Norfolk Vanguard Offshore Wind Farm

Statement of Common Ground

Natural England

Applicant: Norfolk Vanguard Limited
Document Reference: Rep1 - SOCG - 13.1
Revision: 1

Drawing file: published-documents / EN010079-001700-Figure 10.11 Sabellaria Spinulosa Abundance.pdf

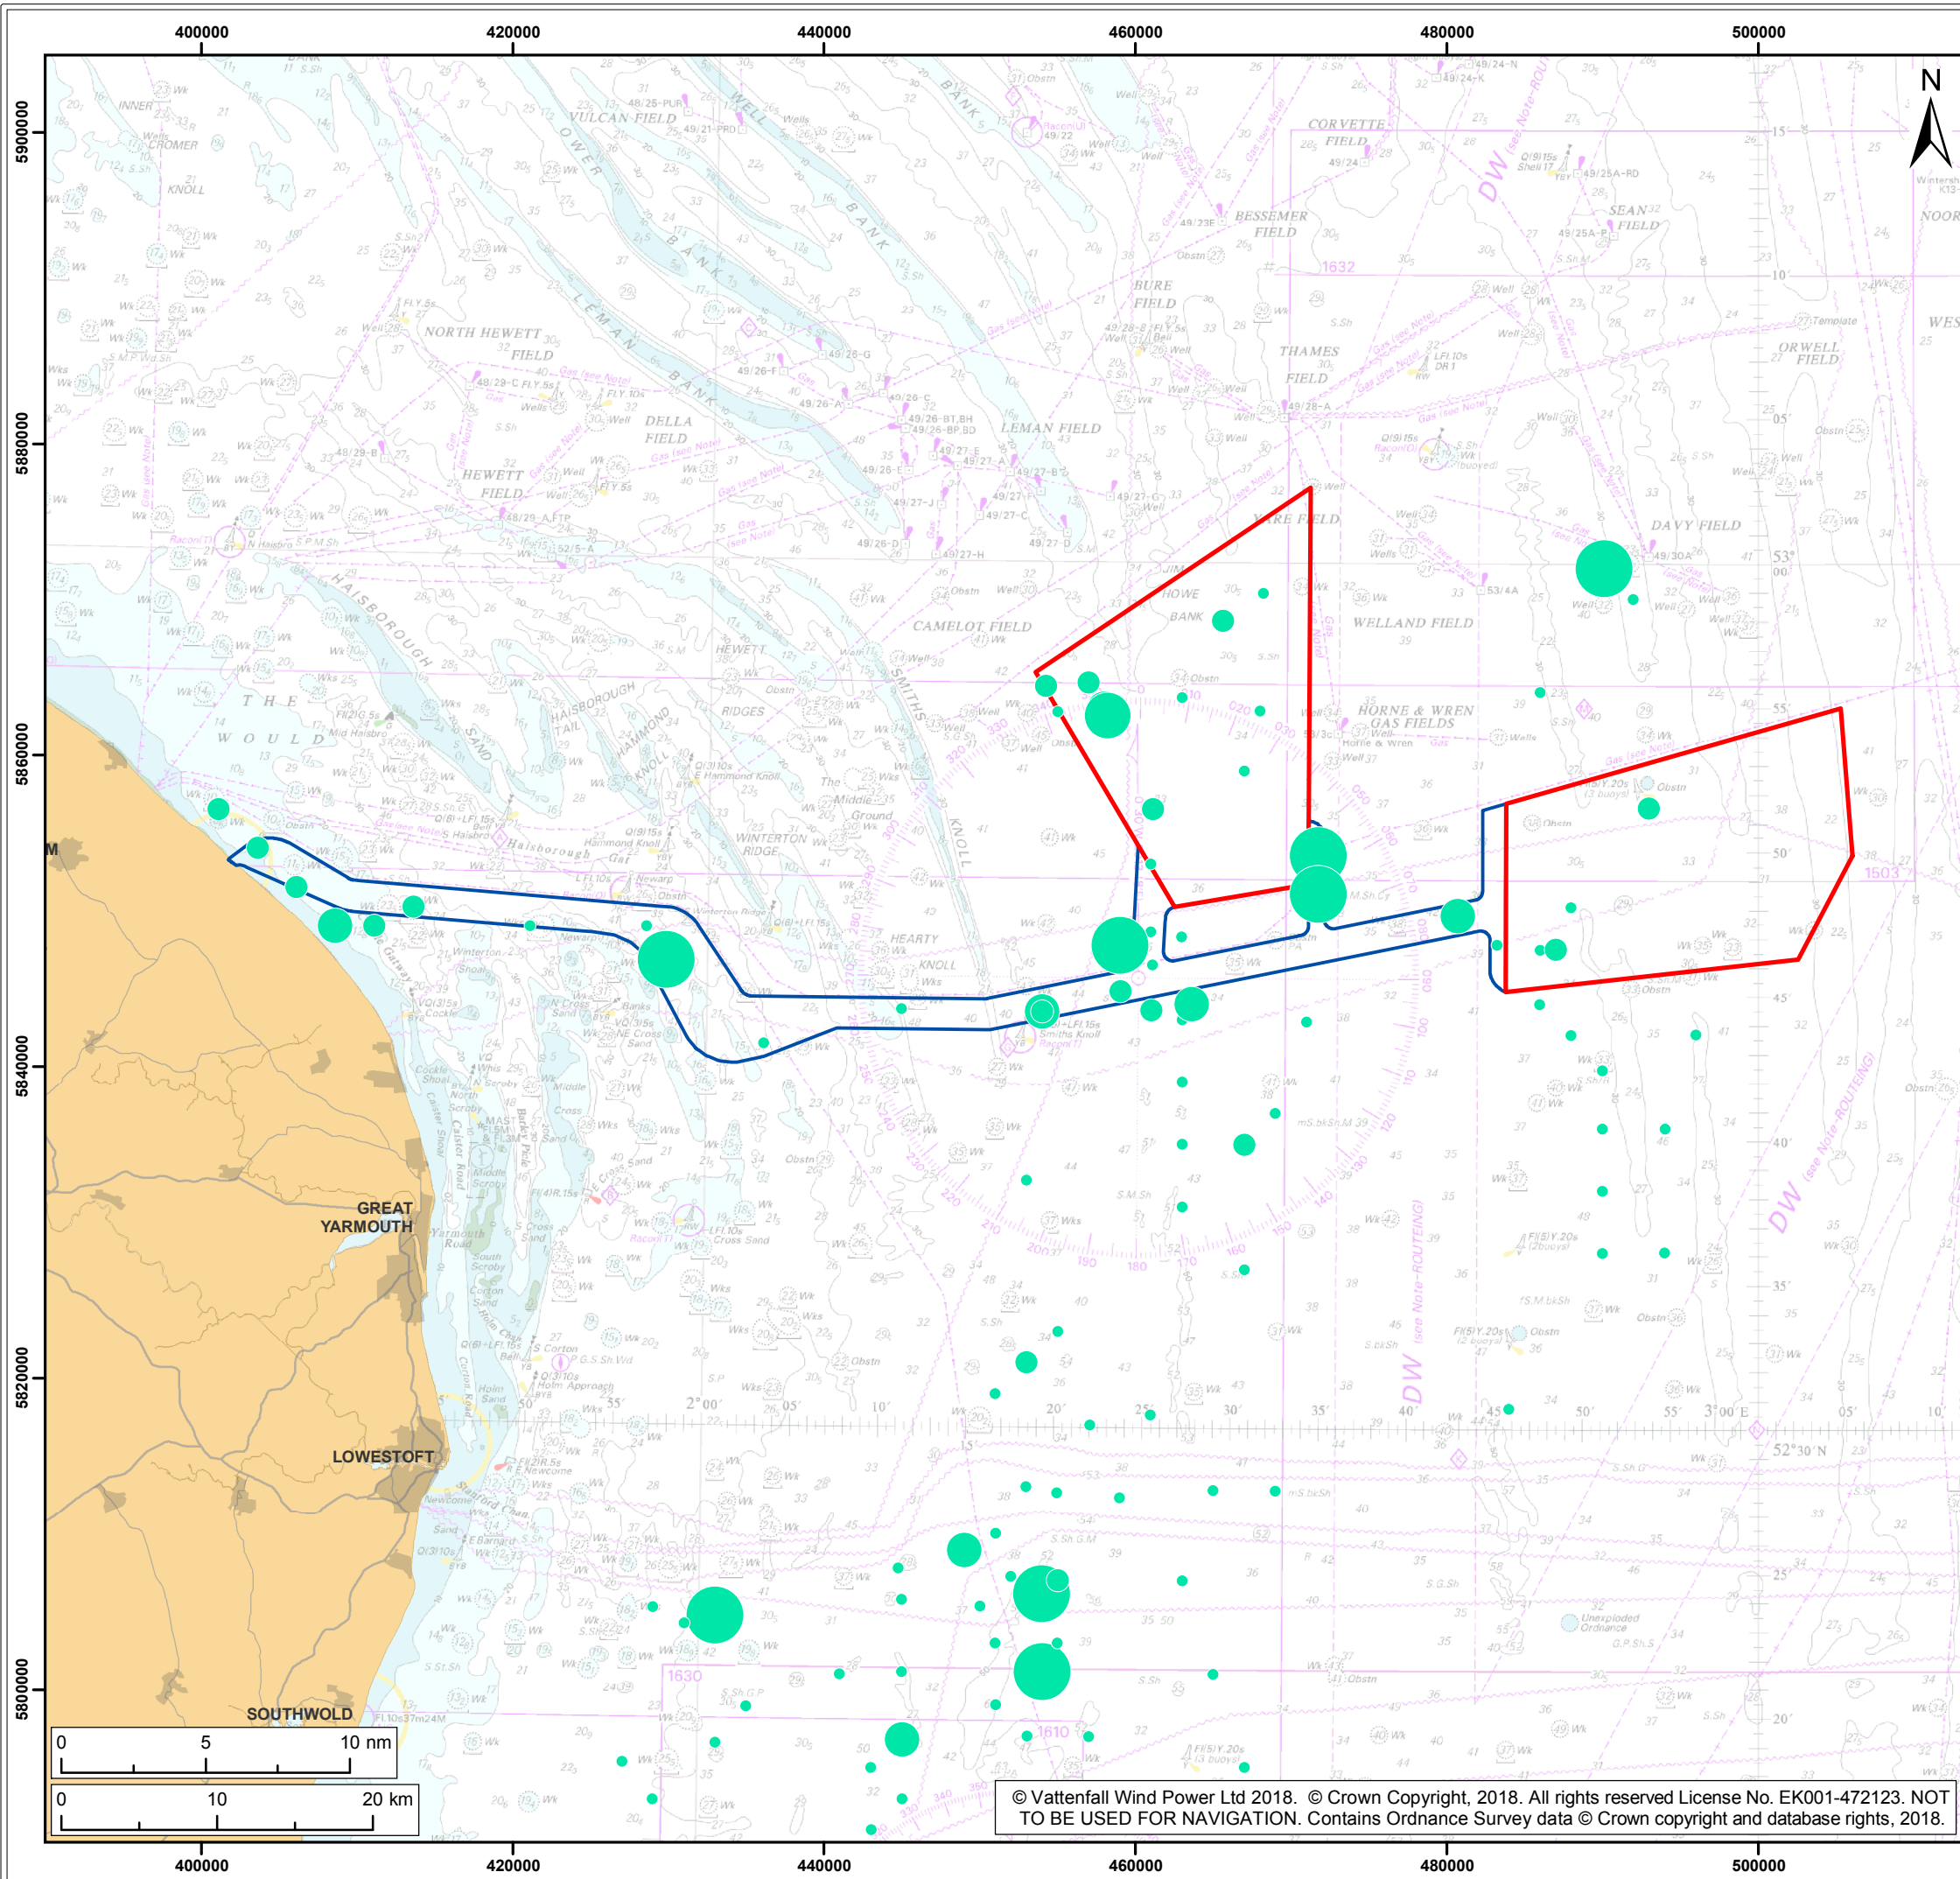
The approach to <i>S. spinulosa</i> reef mapping is appropriate to inform the EIA based on the data available.	Not agreed. Natural England has uncertainty associated with <i>S. spinulosa</i> reef mapping due to the ephemeral

Topic	Norfolk Vanguard Limited position	Natural England position	Final position
	The assessment does not discount “low reef”. It should be noted however that by definition, “low reef” is inherently patchy (with only 10-20% coverage, Gubbay (2007) ²) and therefore increases the potential for micro-siting. Medium reef also has high potential for micro-siting, being classified by 20-30% coverage.	nature of the reef the use of a range of datasets, and the fact that the applicant has only assessed medium/high quality reef as reef.	
	The mapping of potential <i>S. spinulosa</i> reef by Envision on behalf of Norfolk Vanguard Limited identifies potential reef areas which are largely consistent with areas Natural England has identified (as shown on Figure 2.1 below).	Agreed	It is agreed by both parties that the mapping of potential <i>S. spinulosa</i> reef by Envision on behalf of Norfolk Vanguard Limited identifies potential reef areas which are largely consistent with areas Natural England has identified.

<p><i>S. spinulosa</i> is an ephemeral, rapidly growing opportunistic species; pre-construction surveys targeted at establishing the presence, location and extent of <i>S. spinulosa</i> reef habitats are therefore required to enable effective micro-siting where possible.</p> <p>The assessment provides consideration of the impacts if micro-siting is possible and if it is not possible (see Assessment Findings sections below).</p> <p>A cable specification, installation and monitoring plan, must be agreed with the MMO in consultation with Natural England as discussed under ‘Mitigation and Management’ below. This will provide the mechanism to agree cable routing/micro-siting.</p>	<p>Not agreed, parameters/clear commitments are required in the DCO rather than the simple statement “where possible”.</p> <p>Natural England would want to see that all Annex I <i>S. spinulosa</i> will be avoided.</p> <p>The impact on <i>Sabellaria spinulosa</i> reef needs to be fully assessed if micro-siting is not possible and cable installation is still permitted.</p>
